Our Ref: BR/125/19/PL

**Town & Country Planning Act 1990 (as amended)
Town and Country Planning (Development Management Procedure) (England) Order 2015
Application for Full Planning Permission**

Development Side and extension to existing mixed use building to provide additional retail space at ground level, 1 No. first floor studio flat & 2 No. studio flats to new roof extension.

Location 1-2 The Parade Argyle Road Bognor Regis

project title		date	project no
1-2 Argyle Road, Bognor Regis		08-2018	1810
drawing title	scale	drawing no	Guy Walker Architects New Olives, High Street, Uckfield, East Sussex TN22 1QE. Tel: 0779 9061715
Existing and Proposed Street Scene	1:50@ A3	PL04	
		status	revision no.
		Planning	/

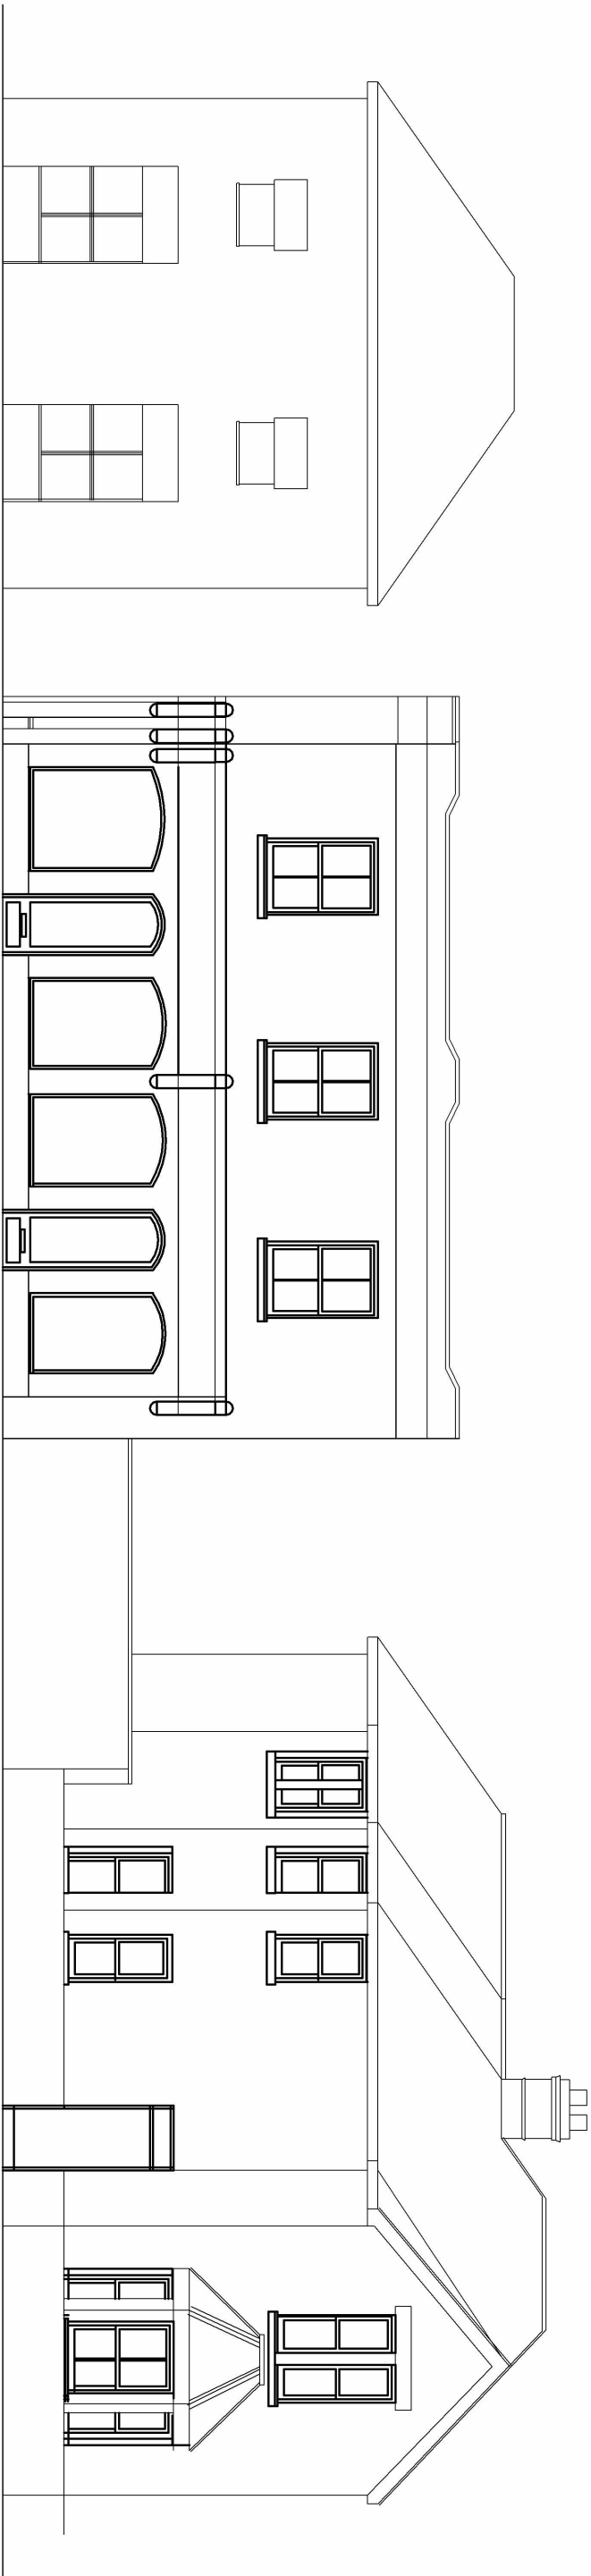
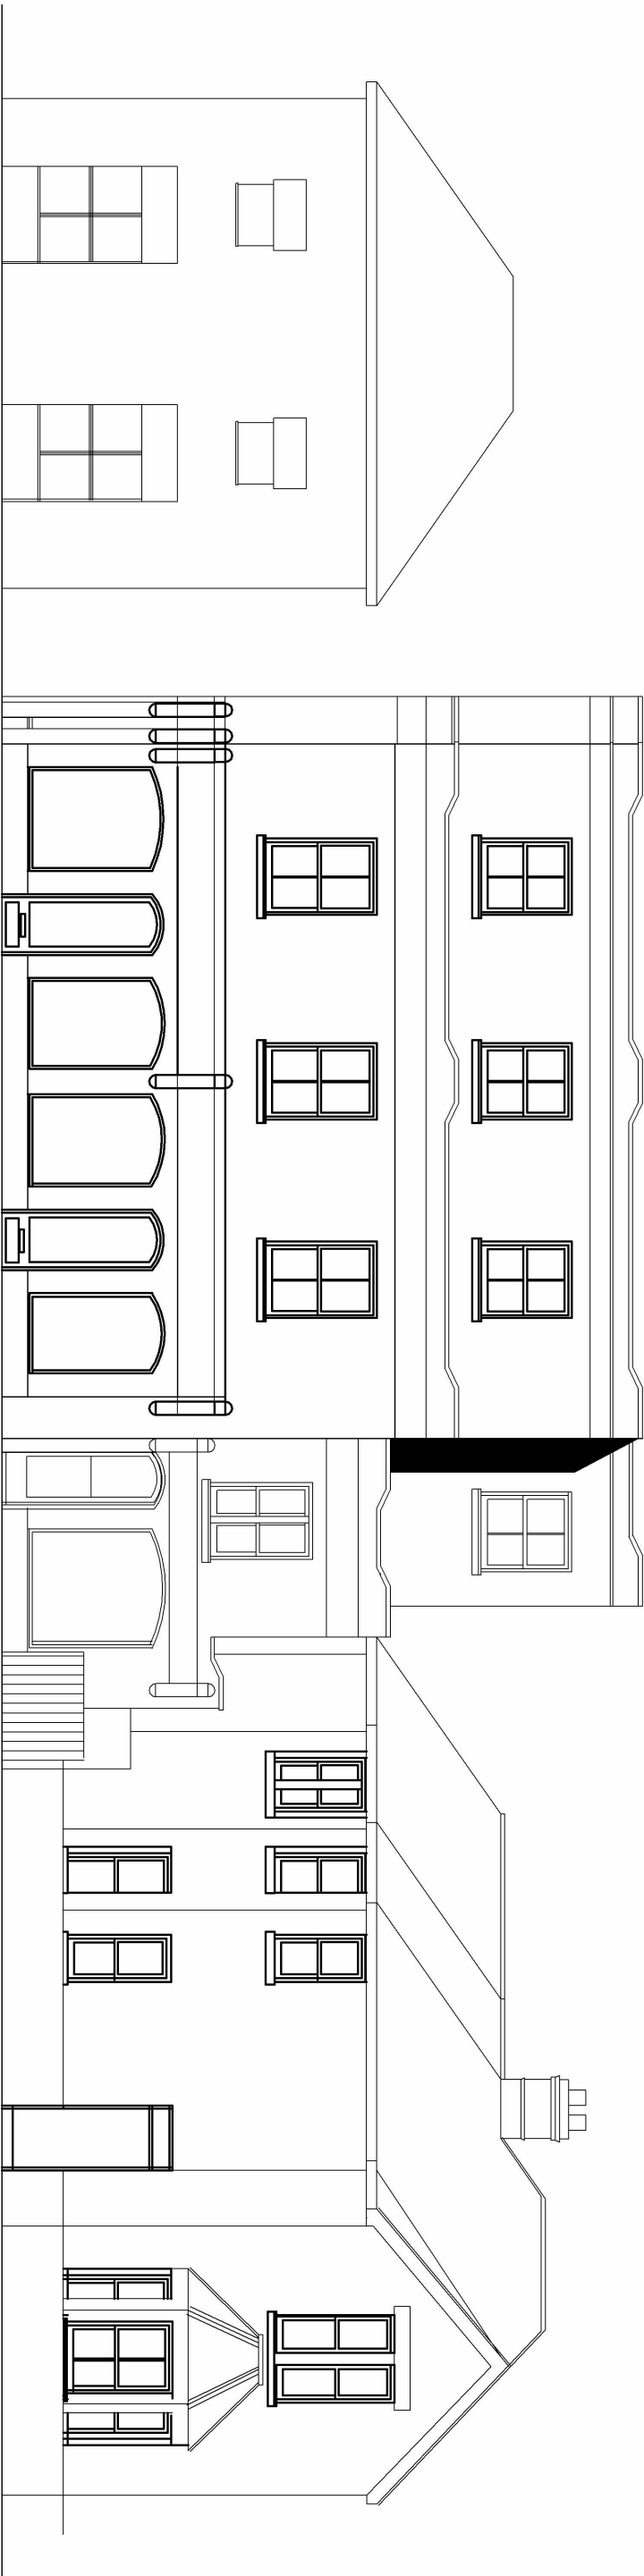
Street Scene

For all planning applications both residential and commercial which propose development set between existing buildings visible from the public realm it is a Local Validation Requirement to provide a street scene drawing or photomontage.

project title
1-2 Argyle Road, Bognor Regis
drawing title
Existing Elevations

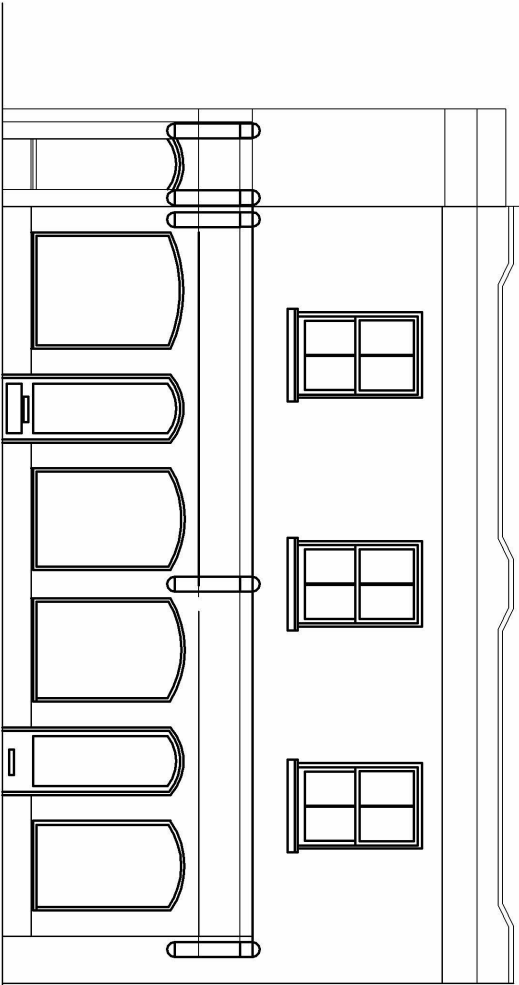
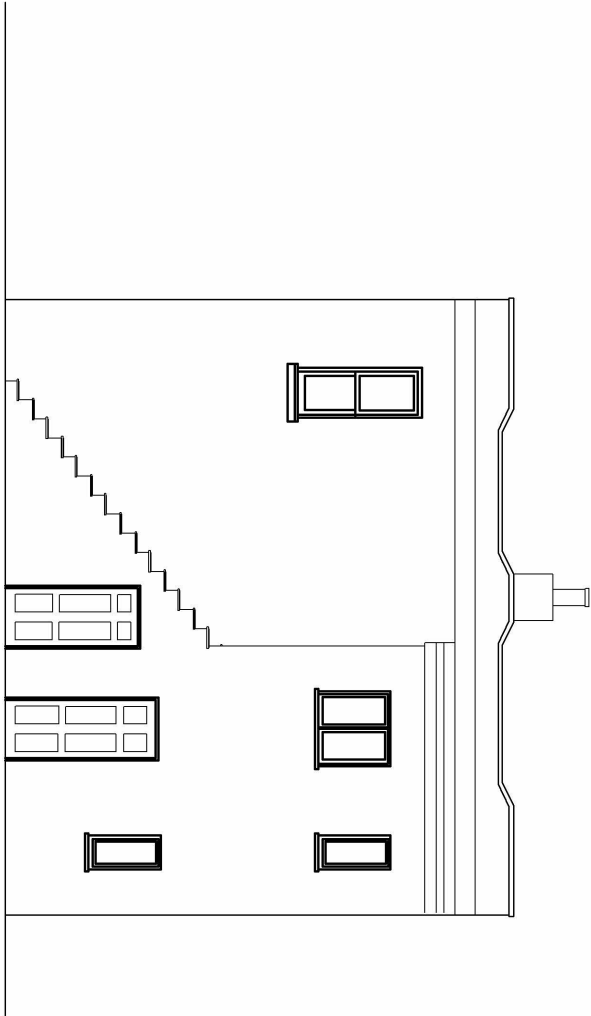
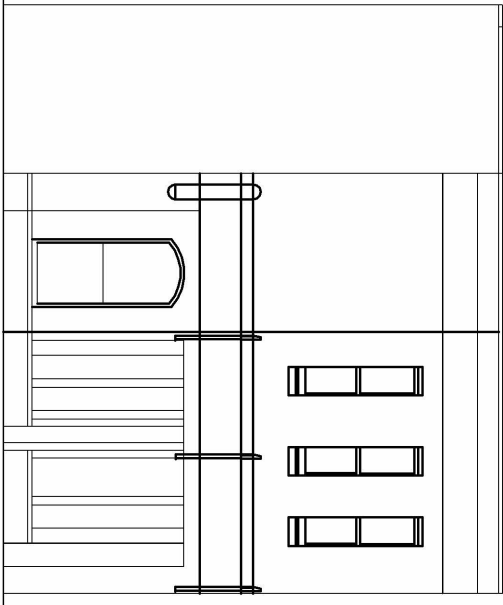
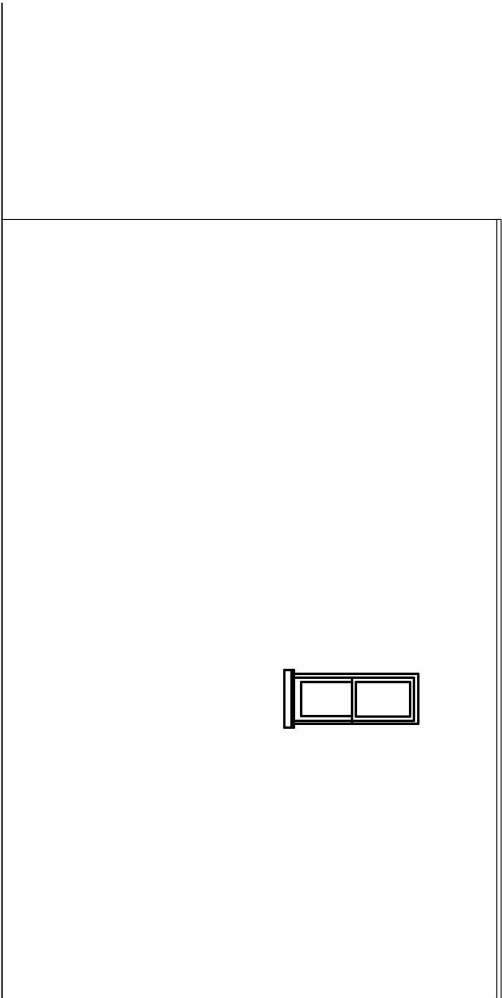
Please provide existing floor plans and elevations.

Site Plan Scale 1:200

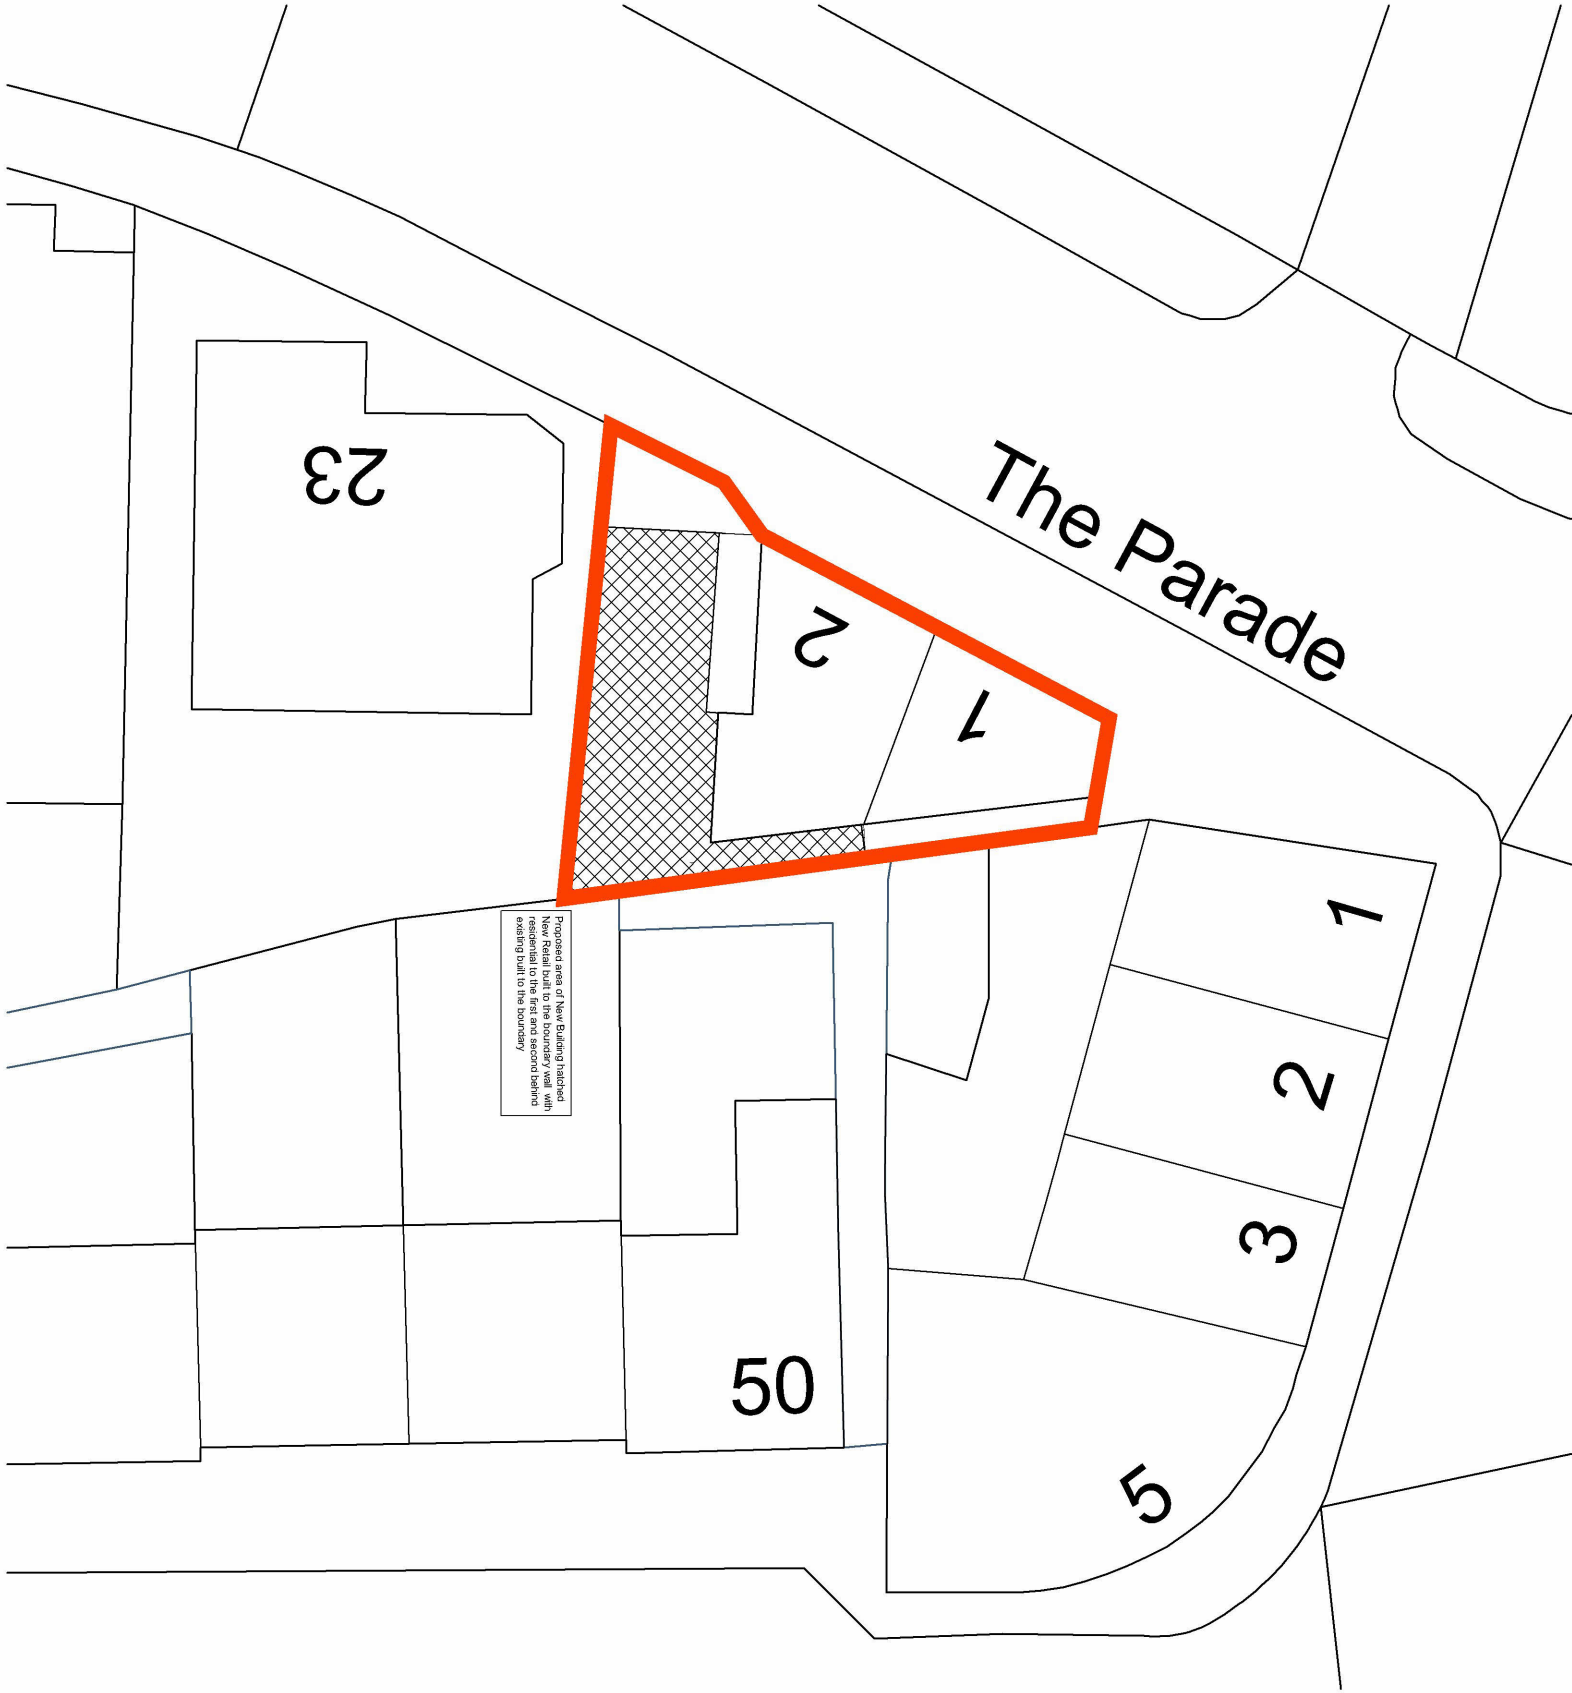
Block Plan Amend

Please hatch/highlight all proposed works and provide measurements from the proposed retail extension to the site boundaries.

| drawing title | Proposed Elevations           |

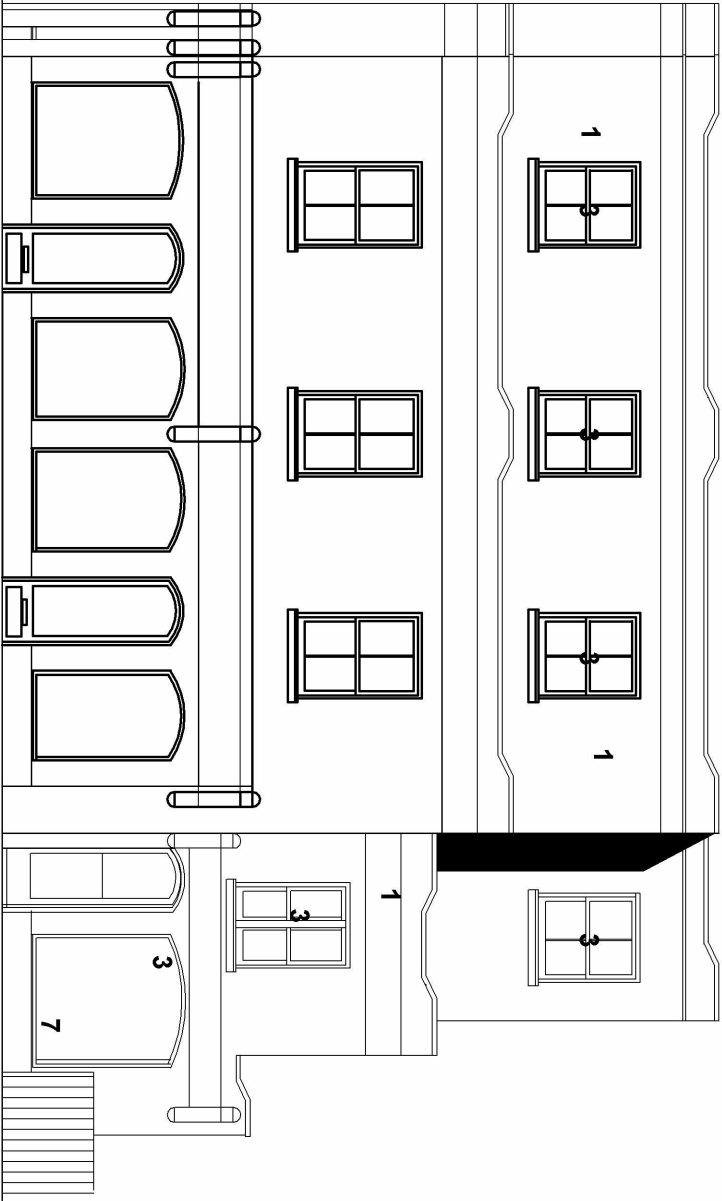
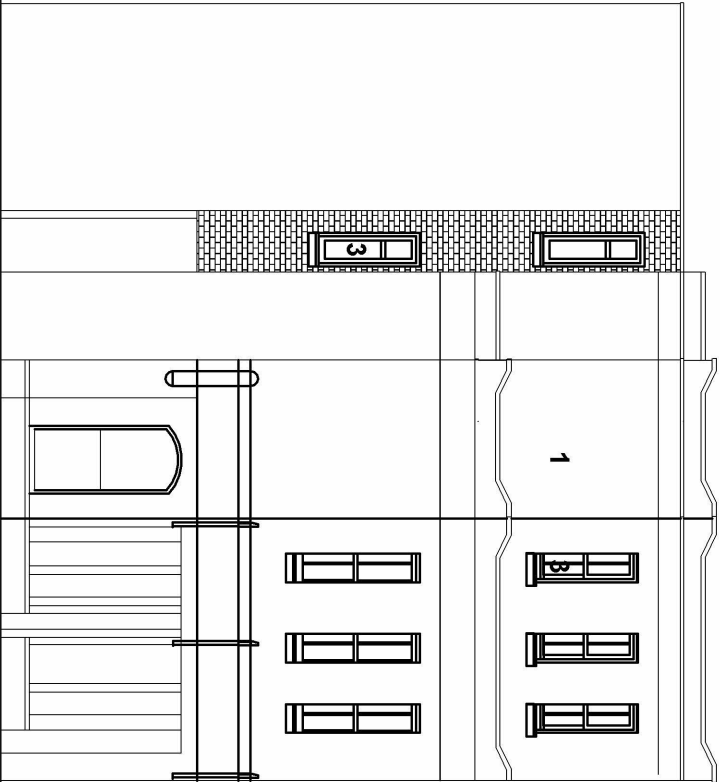
The proposed west elevation and second floor plan do not accord. Please amend accordingly.

The proposed east elevation and first floor plan do not accord. Please amend accordingly.
